Application for Planning Permission for Works or Extension to a Dwelling

Development: resubmission of FP/25/25/HH
Location: 69 Crossbush Road Felpham PO22 7LY

Proposed Roof Plan

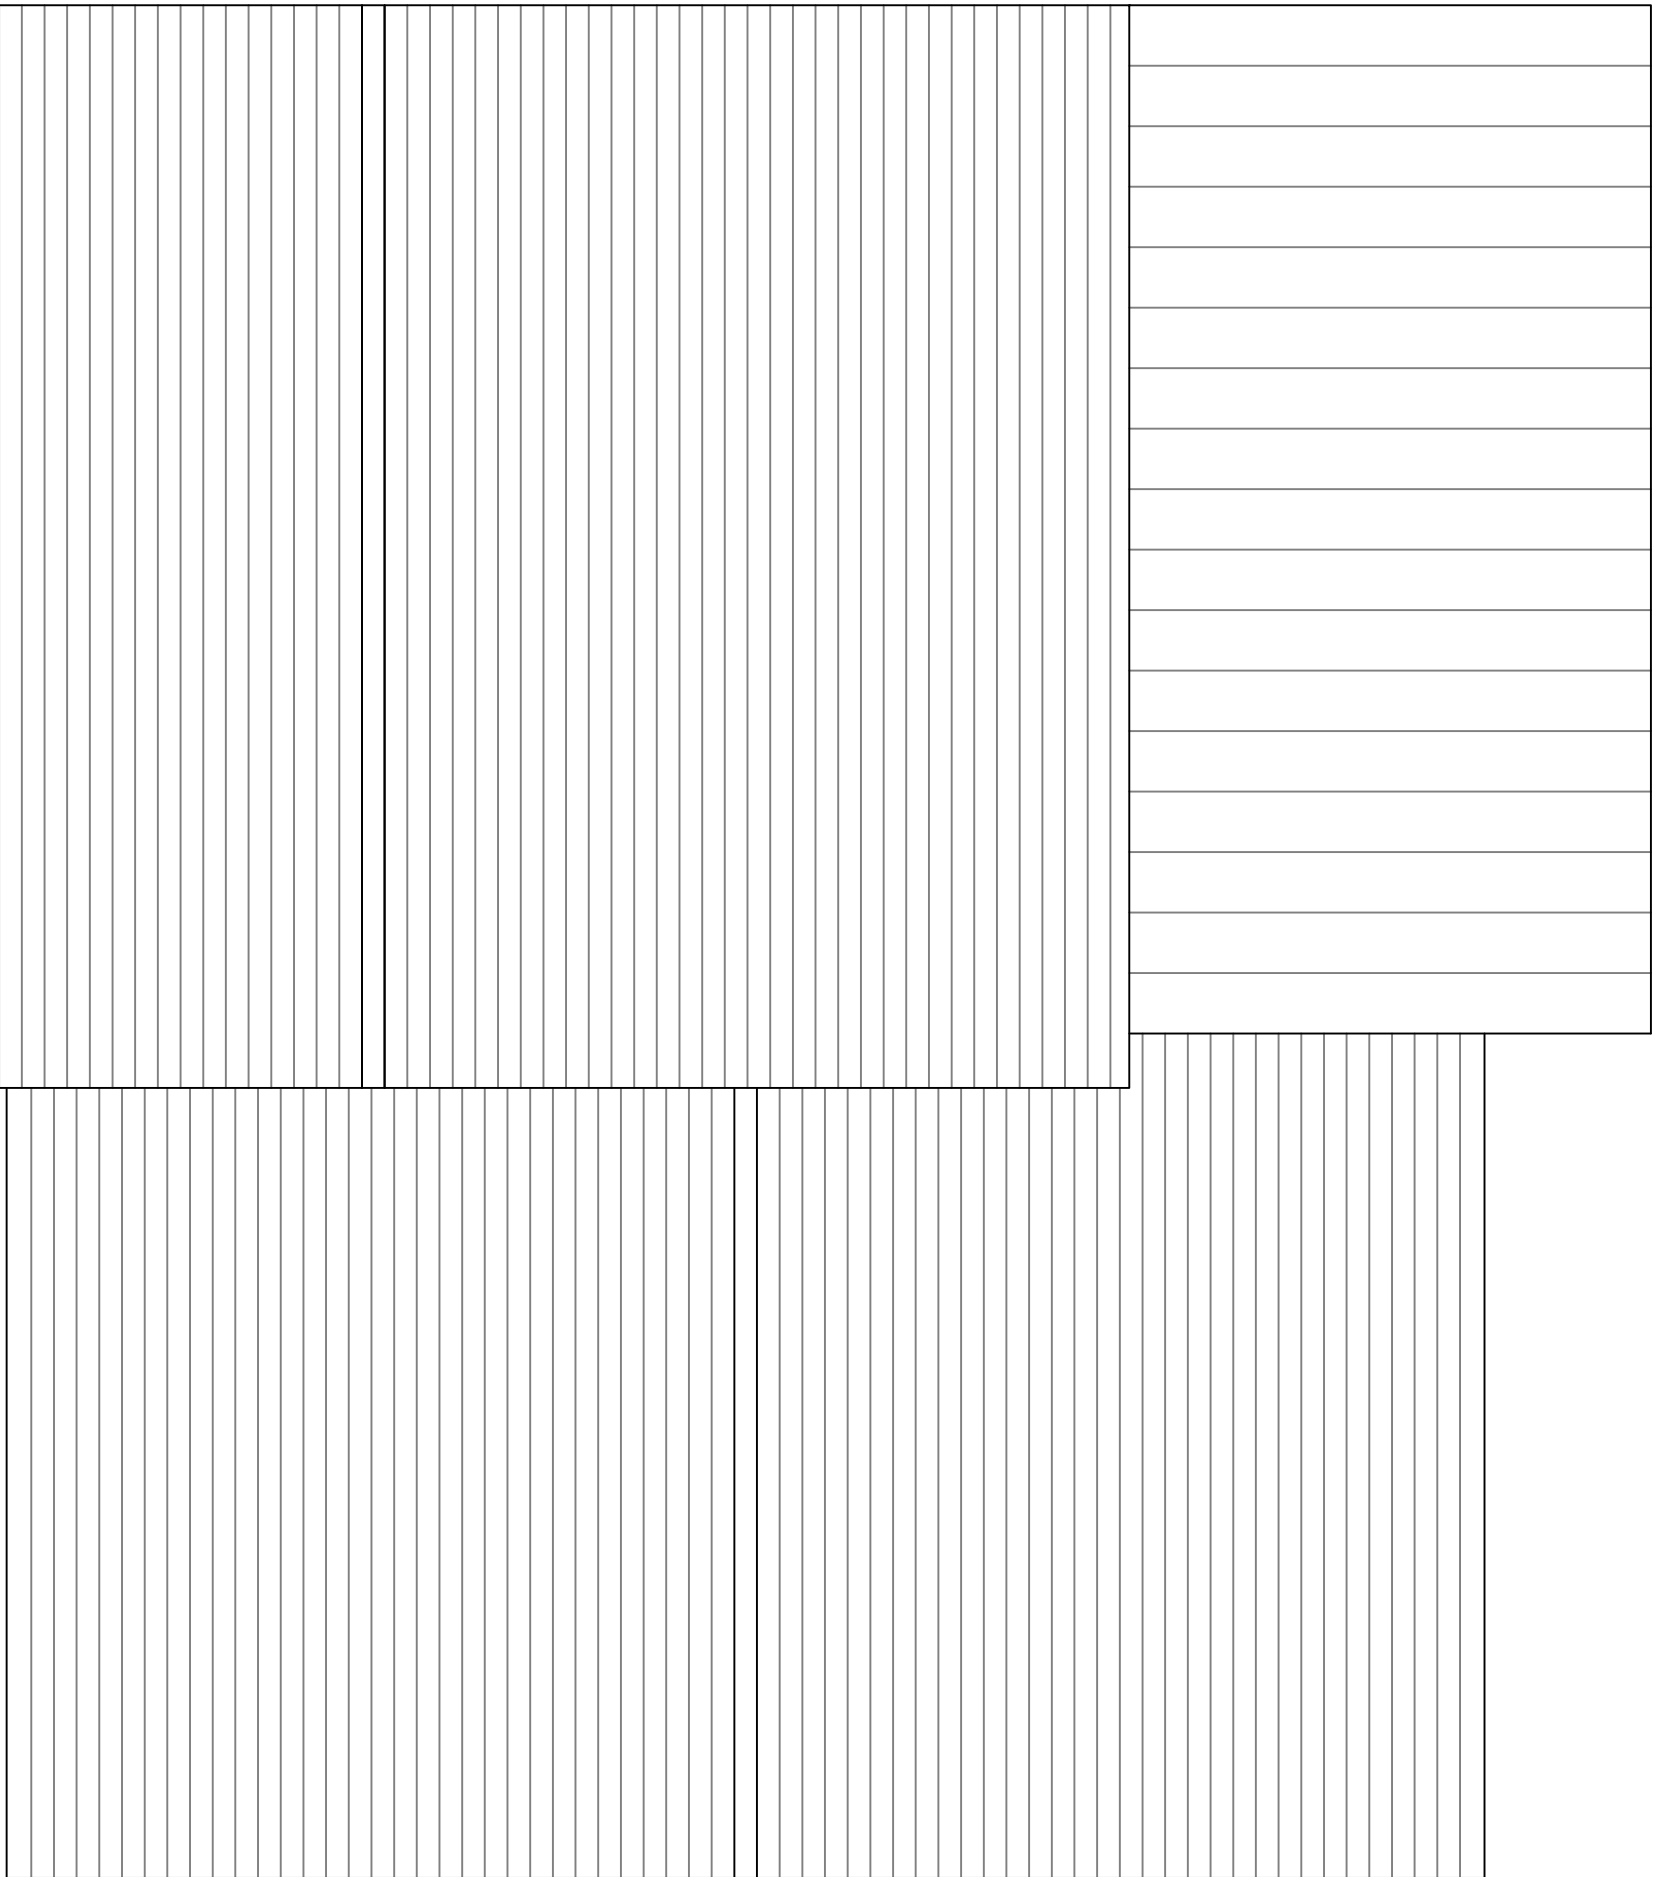
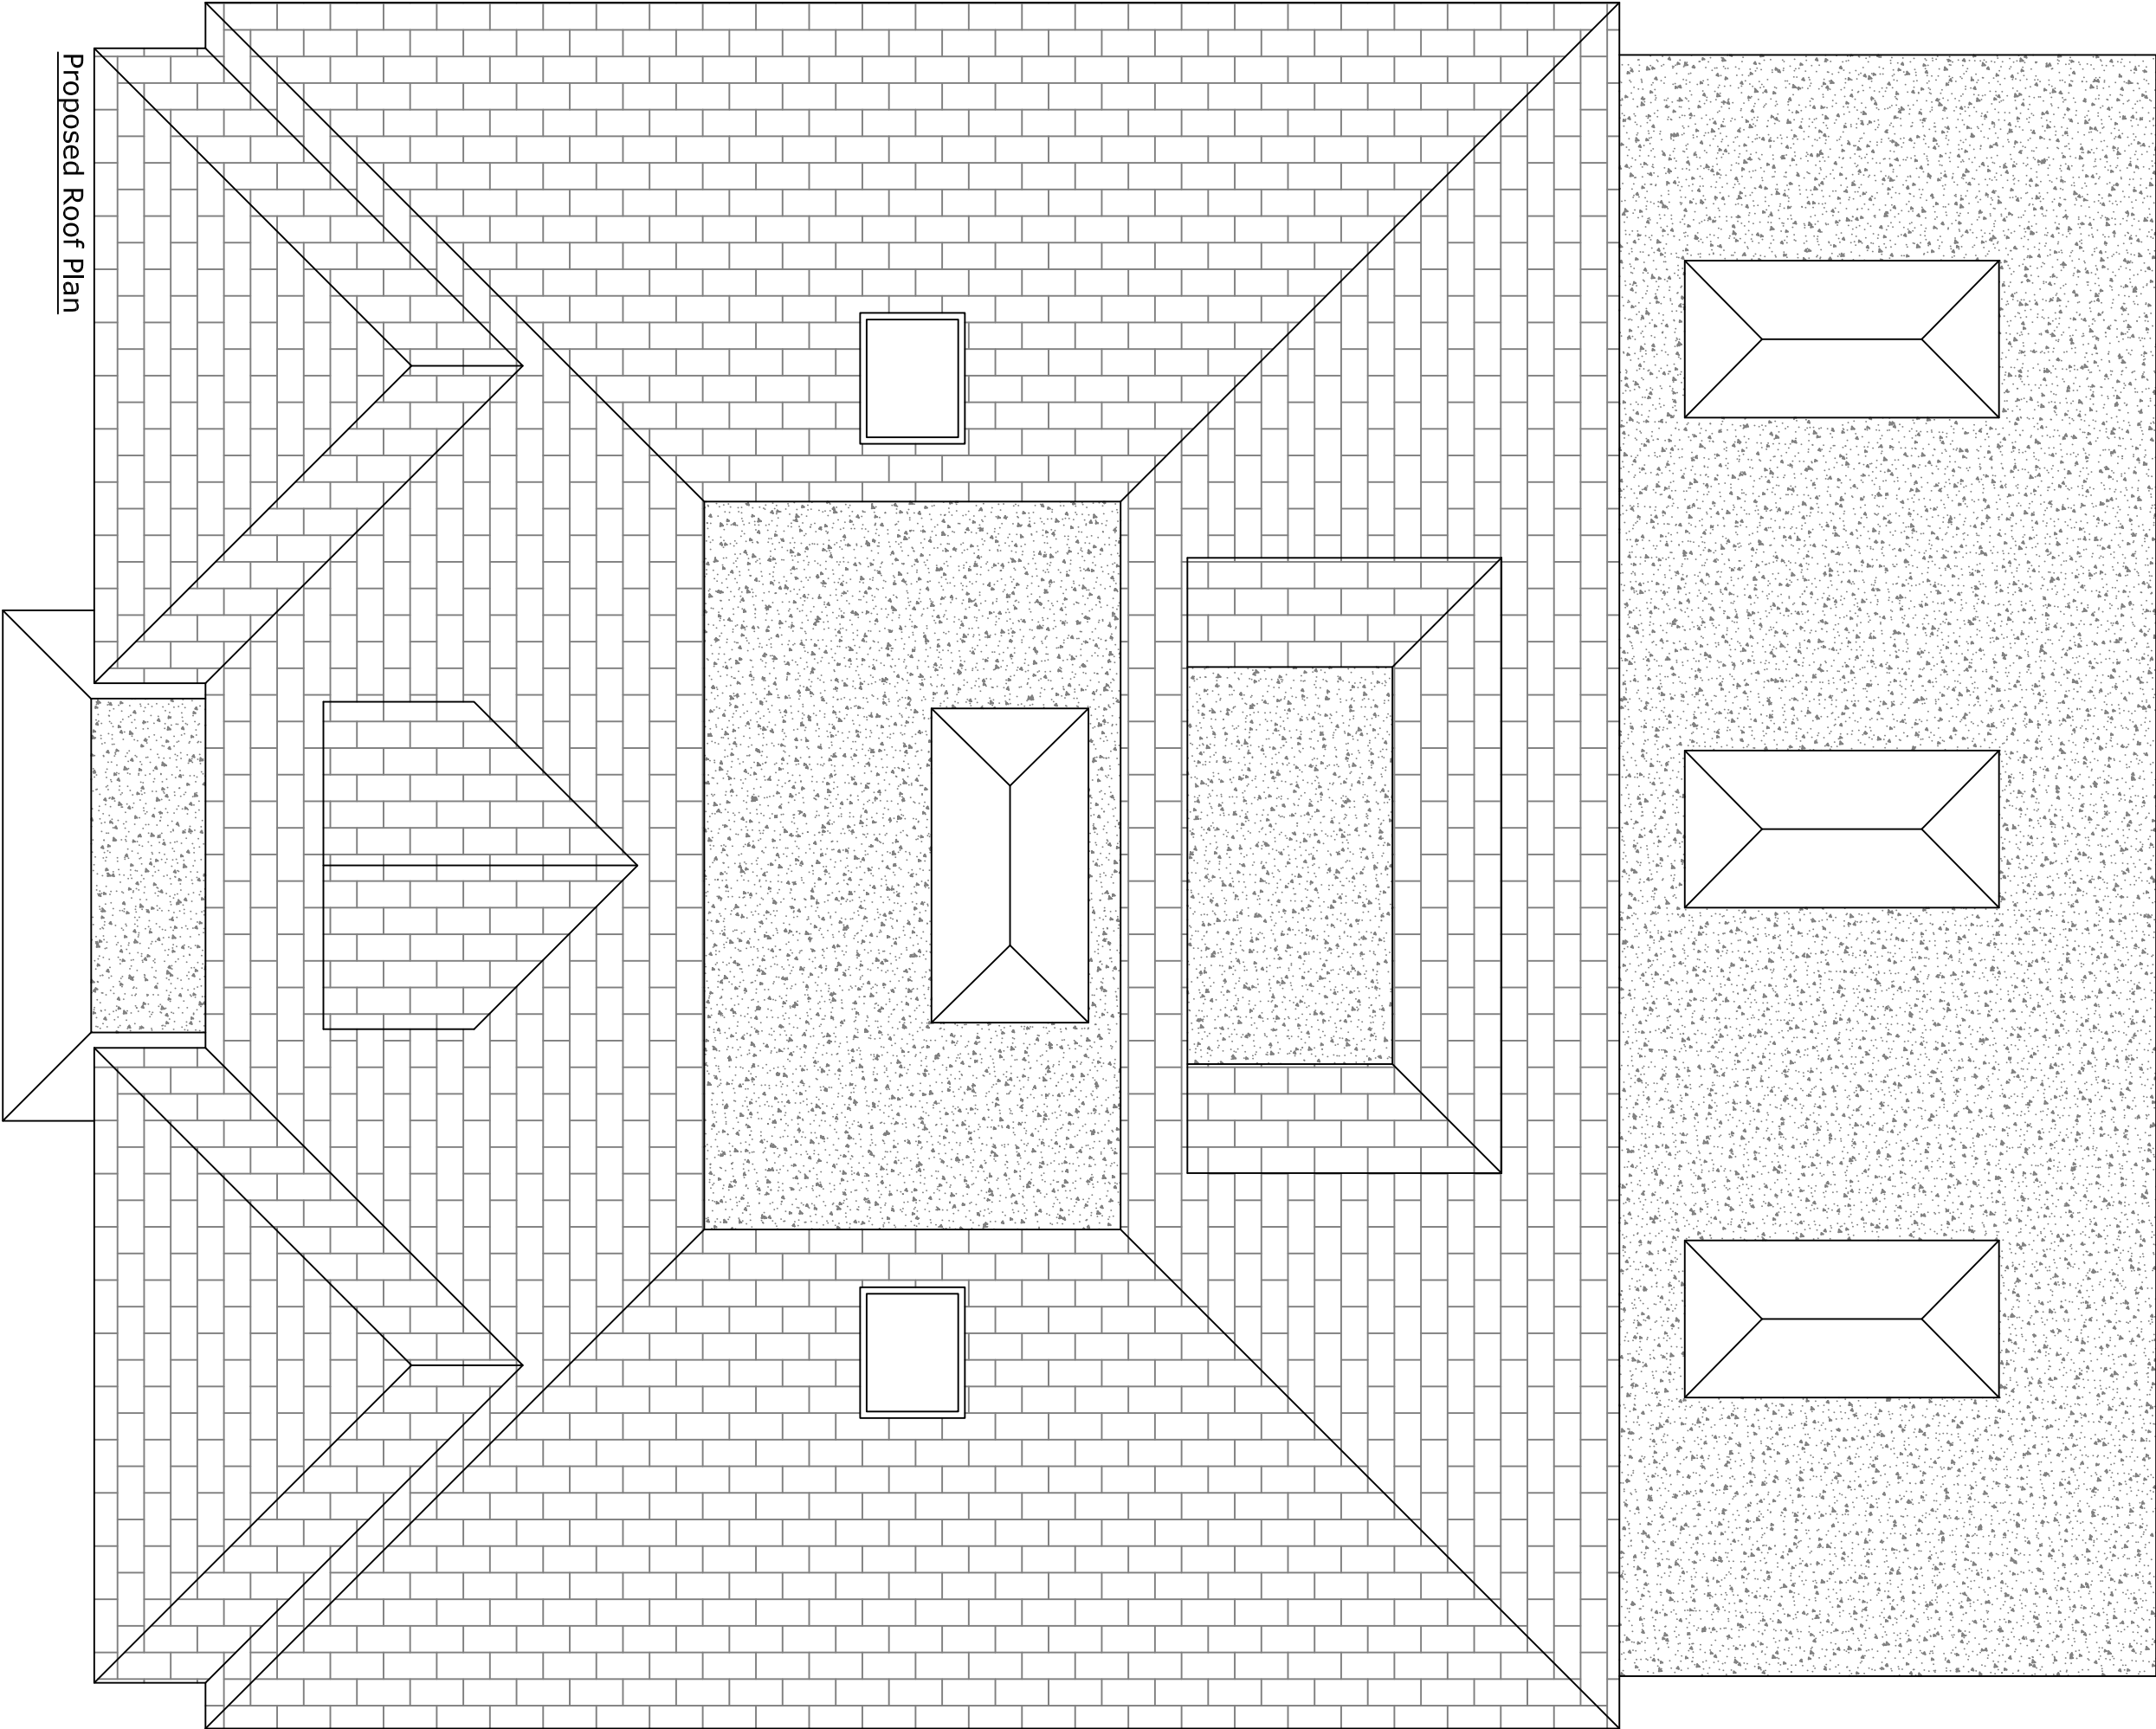
No roof plans have been provided.
